NOTICE OF DECISION

Proposal: Erection of an agricultural barn store (re-submission of 20/03347/F)

Location: The Pheasant Pluckers Inn, Burdrop, OX15 5RQ

REFUSAL OF PERMISSION FOR DEVELOPMENT

SKETCH VIEW IMPRESSION OF PROPOSED BARN FROM THE WEST

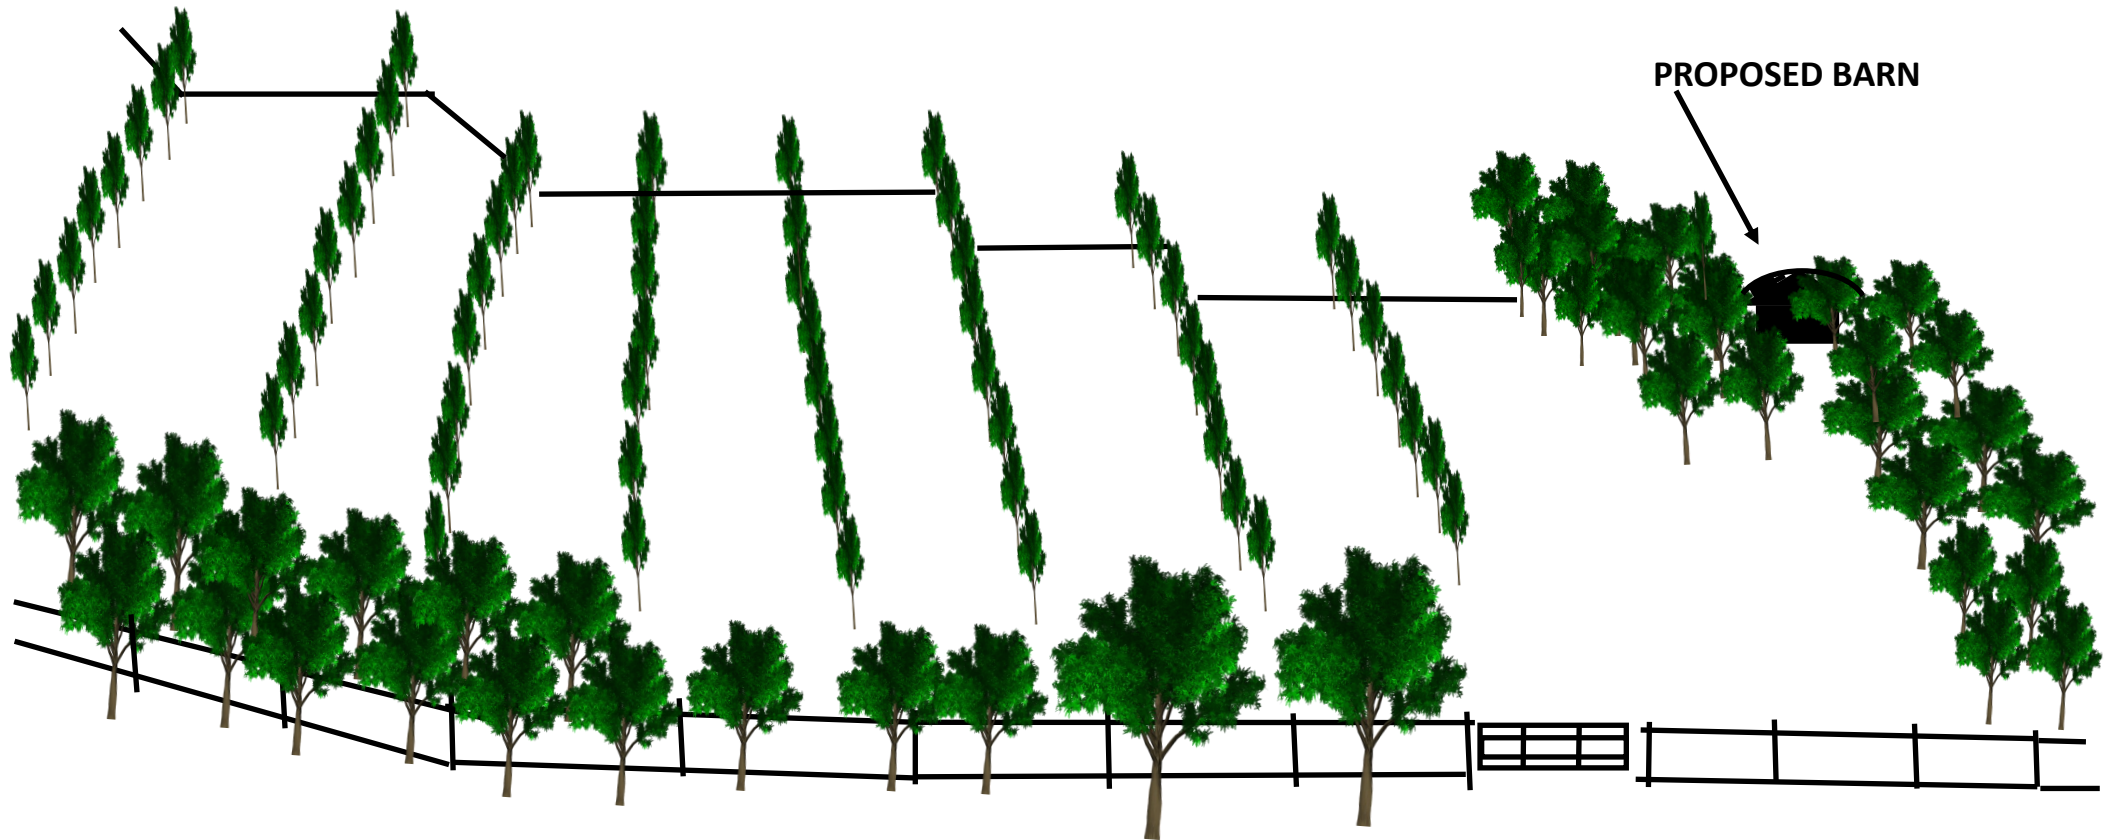
1. The proposed building, by reason of its form, scale, appearance and prominent siting within the Sib Valley in open countryside, would cause significant visual intrusion and would adversely affect the undeveloped character, attractive qualities and appearance of the landscape of the Sib Valley and would cause harm to the character and appearance of the Sibford Gower with Burdrop Conservation Area. It has not been demonstrated that there is an essential need for the building in this location and insufficient information has been received in order to assess the viability of the proposed business use, and therefore the identified harm significantly and demonstrably outweighs any benefits arising from the proposal. The proposal therefore fails to accord with Policies ESD1, ESD13 and ESD15 of the Cherwell Local Plan (2011-2031 Part 1), Saved Policies AG2, C23, C28 and C33 of the Cherwell Local Plan (1996) and relevant paragraphs of the National Planning Policy Framework.
